# Falcon Field ReZone Traffic Impact Study

Revise to Master  
Traffic Impact Study

AUGUST 31, 2021

RE: Falcon Field 2021 Rezone  
El Paso County, CO  
Traffic Impact Study  
LSC #S214730

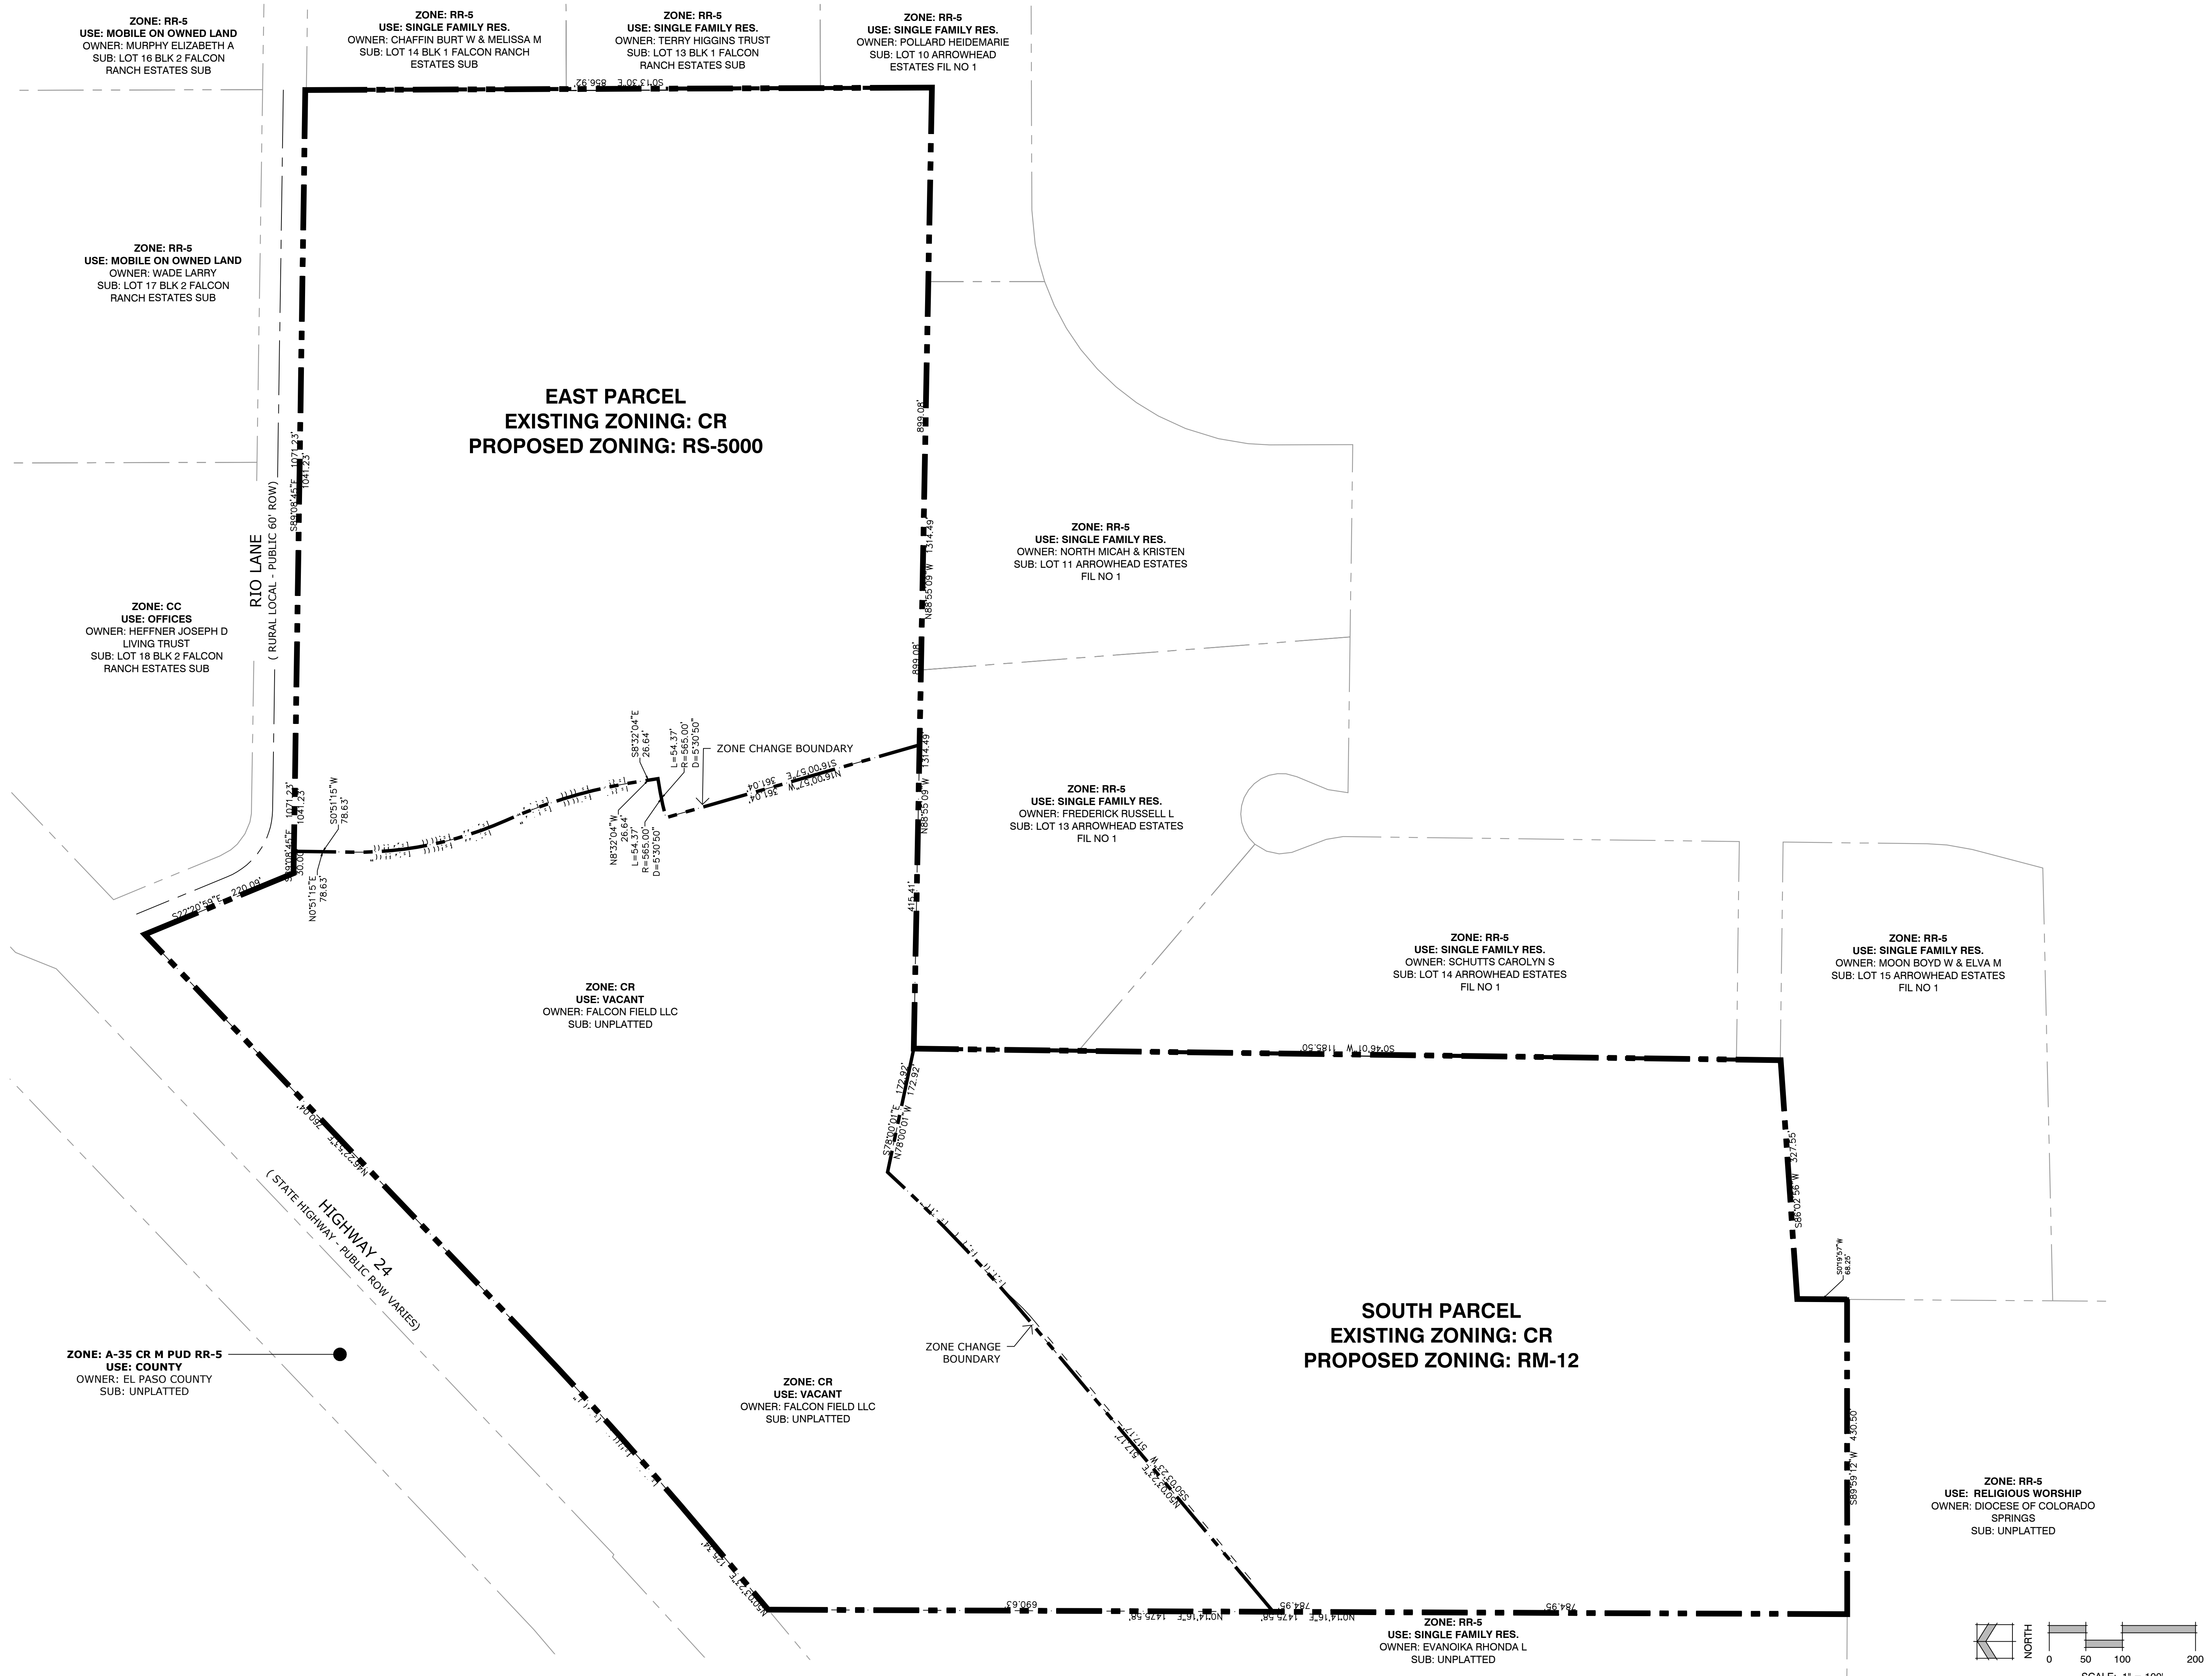
Is it the intent of the developer to provide ROW dedication and/or preservation for the south leg of the roundabout to the southern property line?
